Caitlin Cameron - RE: 169 Newbury - what's missing/comments?

From: David Senus <dsenus@woodardcurran.com>
To: Caitlin Cameron <CCameron@portlandmaine.gov>
Date: 2/15/2016 12:40 PM
Subject: RE: 169 Newbury - what's missing/comments?
CC: "David Margolis-Pineo - Portland, City of (DMP@portlandmaine.gov)" <DMP@...

4 OIL INTERCEPTOR PIT DETAIL NOT TO SCALE

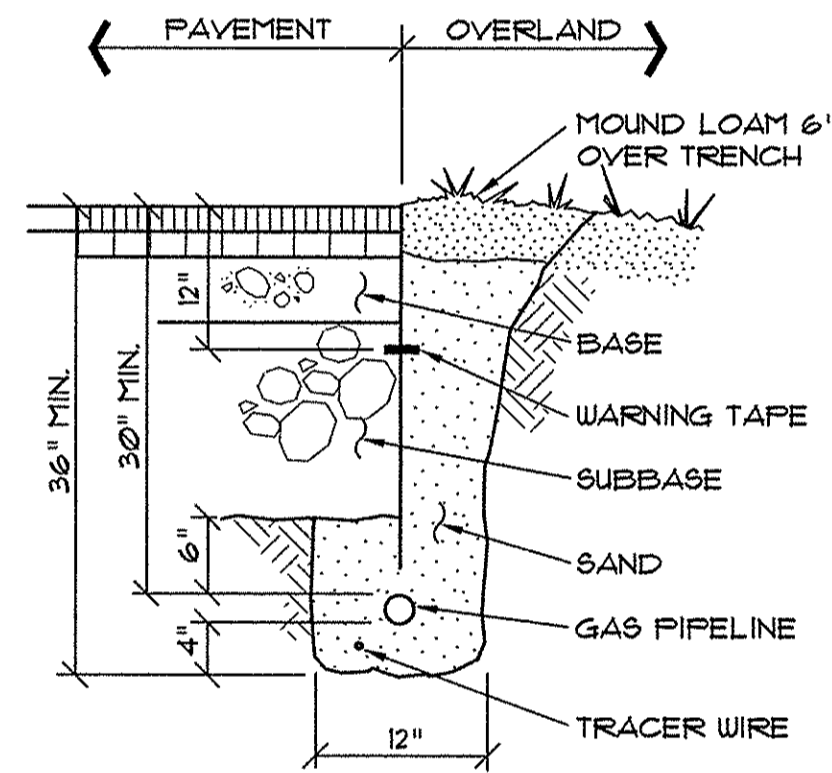
- Green Roof System – Provide plans/details for the green roof system, and a report that includes calculations and an evaluation of how the green roof will provide water quality treatment and how the system will reduce flowrate into the City's combined sewer system.
- Sanitary Sewer – How does the applicant plan to offset the anticipated increase in wastewater flow into the City's combined sewer system? It appears they are proposing a separated storm drain along the curb-line of Newbury Street, which seems like an appropriate solution. DPW to review and comment.
- A lighting photometric plan and cut sheets for proposed lighting fixtures should be provided for the City's review
- An oil/water separator should be provided for parking garage floor drains; all parking garage floor drains/catch basins should be routed through O/W separator prior to discharge into the combined sewer
